Additional Comments with regards to responses and previous submissions by the Applicant, Public and Statutory Authorities in the Aquind interconnector proposal.

I am an Interested Party in this proposal. In addition to my previous representation I have since read many of the various documents placed onto the Planning Inspectorate website by the Applicant Aquind Ltd, various Statutory Authorities and the public's responses to the proposal. I have also watched a good proportion of the various virtual hearings held by the Planning Inspectorate.

Compulsory Aquisition Hearing 1 – Appendix 1
- Exhibit 15 Cross-section showing the typical
arrangement of the construction corridor
across Milton Common

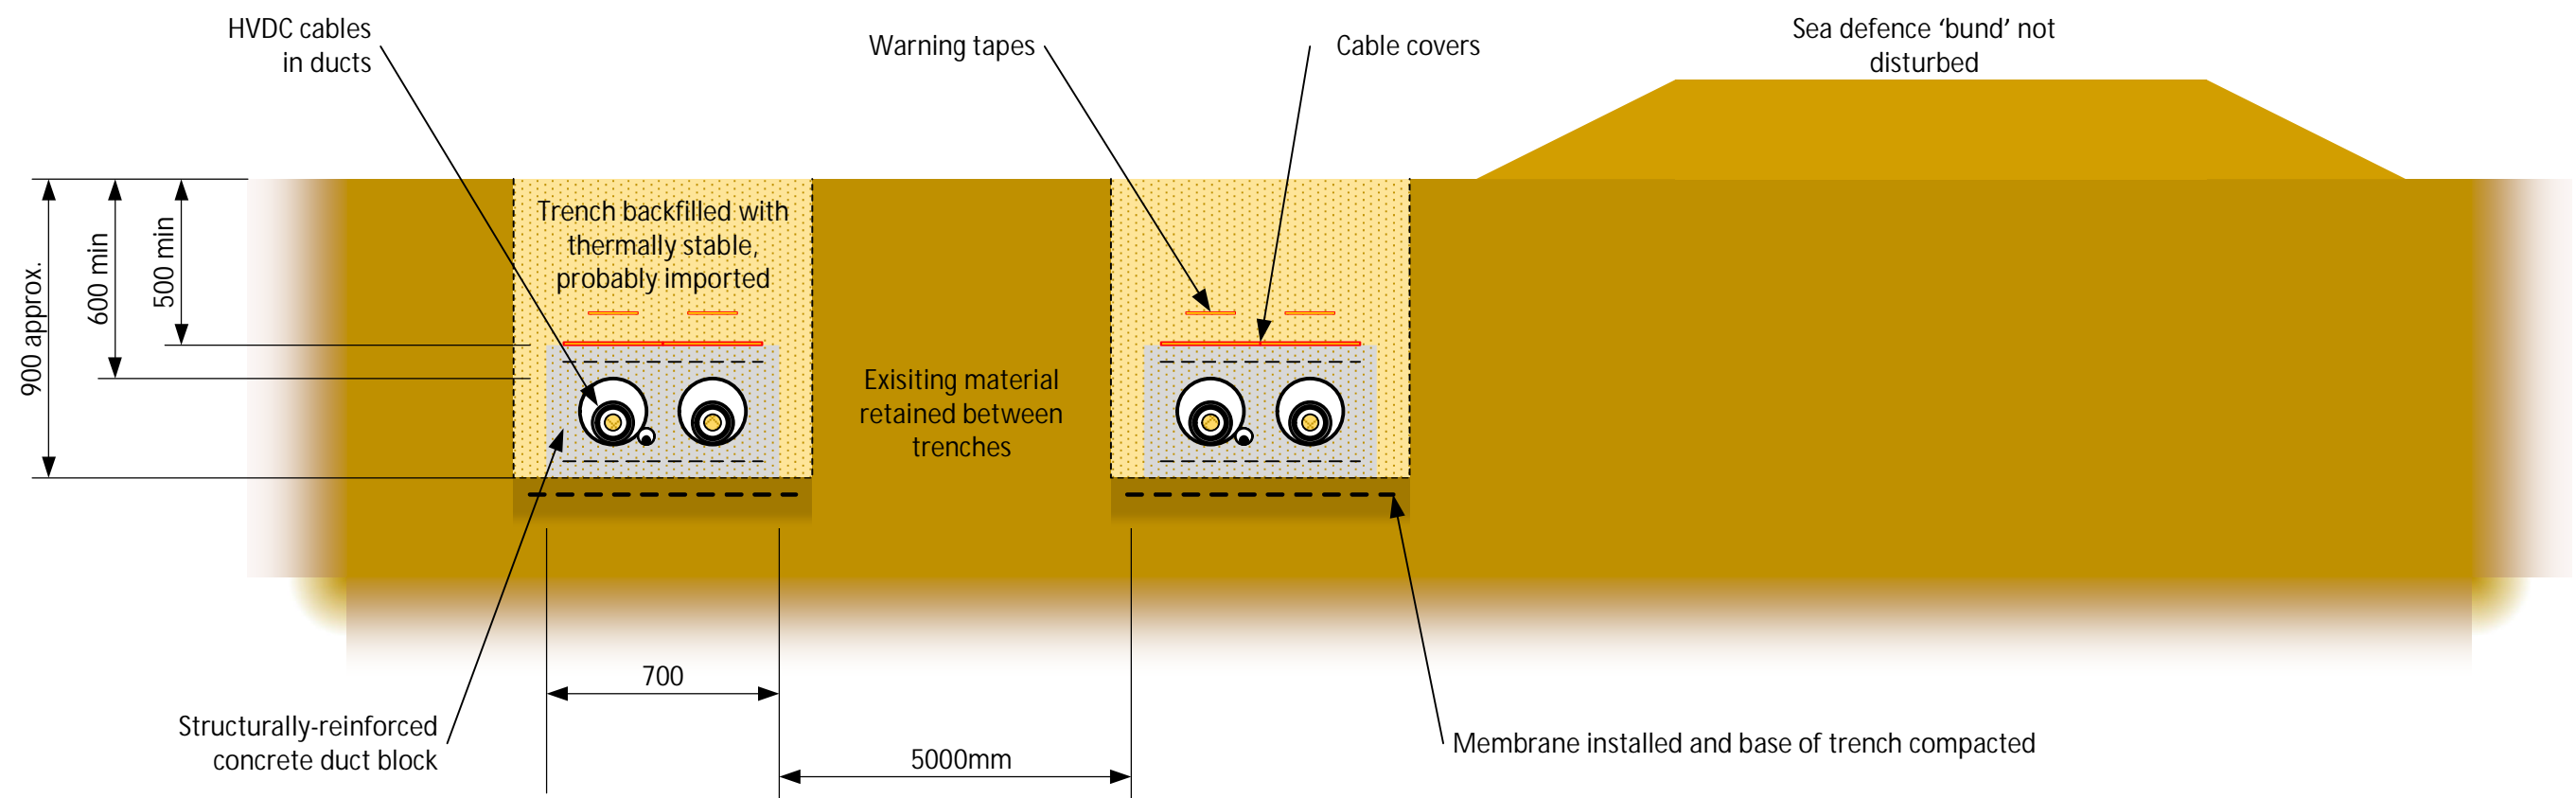
To the north of the University playing fields the proposed cable route leaves those grounds and enters a large copse containing several trees.

How many of the trees and natural habitat does the Applicant assess would need to be destroyed to accommodate the open trenching? I have not seen that mentioned in the reports to date.

Is the applicant also aware that if it is proposed to bring the cables out from this copse it has to cross a pathway? This pathway was installed a few years ago during the coastal defence upgrade. The pathway is in fact a bund created to form part of the secondary sea defence. Where it is proposed to cross the bund sea defence at the northern end of Milton Common the Applicant intends to use a short length of HDD to overcome the problem. Is this then proposed to be the case at the southern end of the bund sea defence as I have described or to open trench the bund?

There are currently 3 options remaining in place in order for the cable route to cross Milton Common. I heard during the hearing that they would prefer the north to south option adjacent to the Sea Defence bund.

I was bewildered during the hearings to hear that the reason why there are 3 different options still proposed. I understand that they haven't ruled out using 2 of the 3 options ie splitting the cable route into paired circuits.

I find this an unbelievable state of affairs. How can recommendations or decisions be made on a 'What if' or 'Just in case' basis unless a definitive route is proposed? Owners in Moorings Way cannot even tell if the carriageway is intended to be used for the cable laying or the grass area of Milton Common in front of their houses used.
